Subject: 2025/90047 at location 178, Marsh Lane, Shepley, Huddersfield, HD8 8AY

Please see ecological commentary below:

FIRST FLOOR PLAN - 1:50

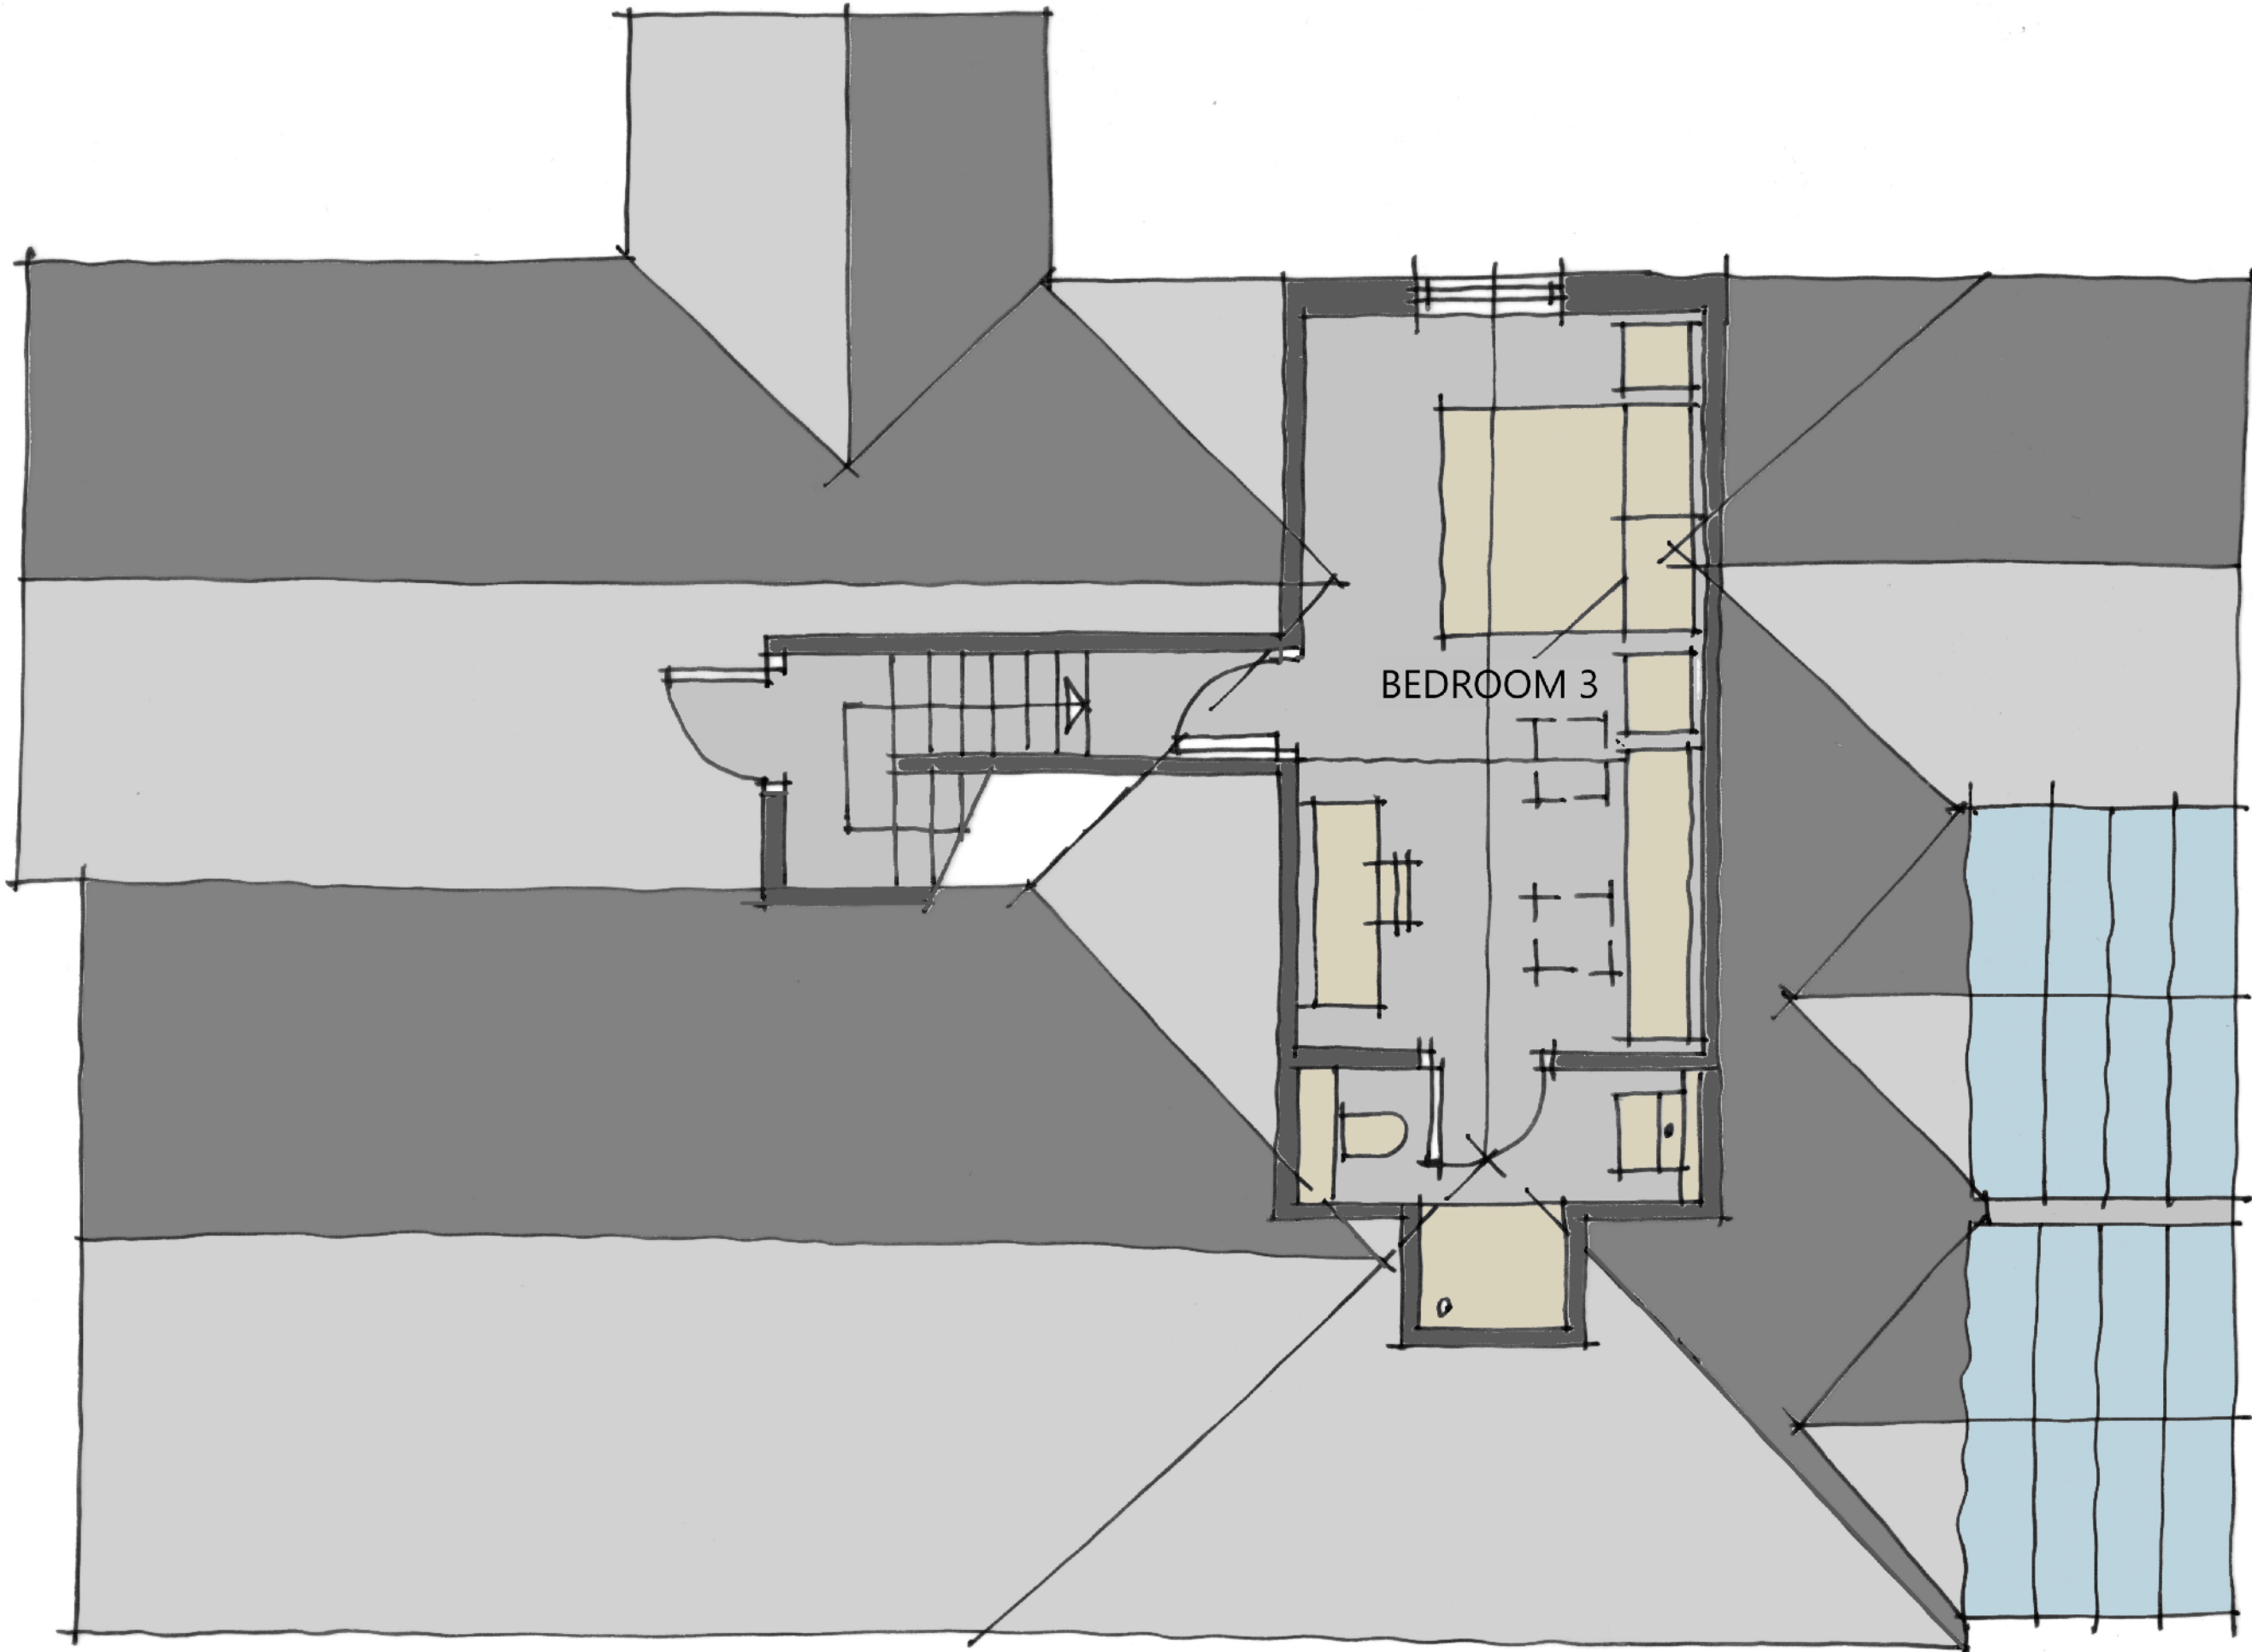
The Preliminary Bat Roost Assessment is reasonable and acceptable. The house was identified as having moderate roosting potential and bat surveys are required to assess whether there are roosts in the buildings. The Bat Survey report provided is reasonable and acceptable. No bats were observed emerging from the House. Precautionary measures are advised, which can be mentioned in an informative. Enhancements are also encouraged with a bat tube on the new building.

- 1 no. integrated bat box
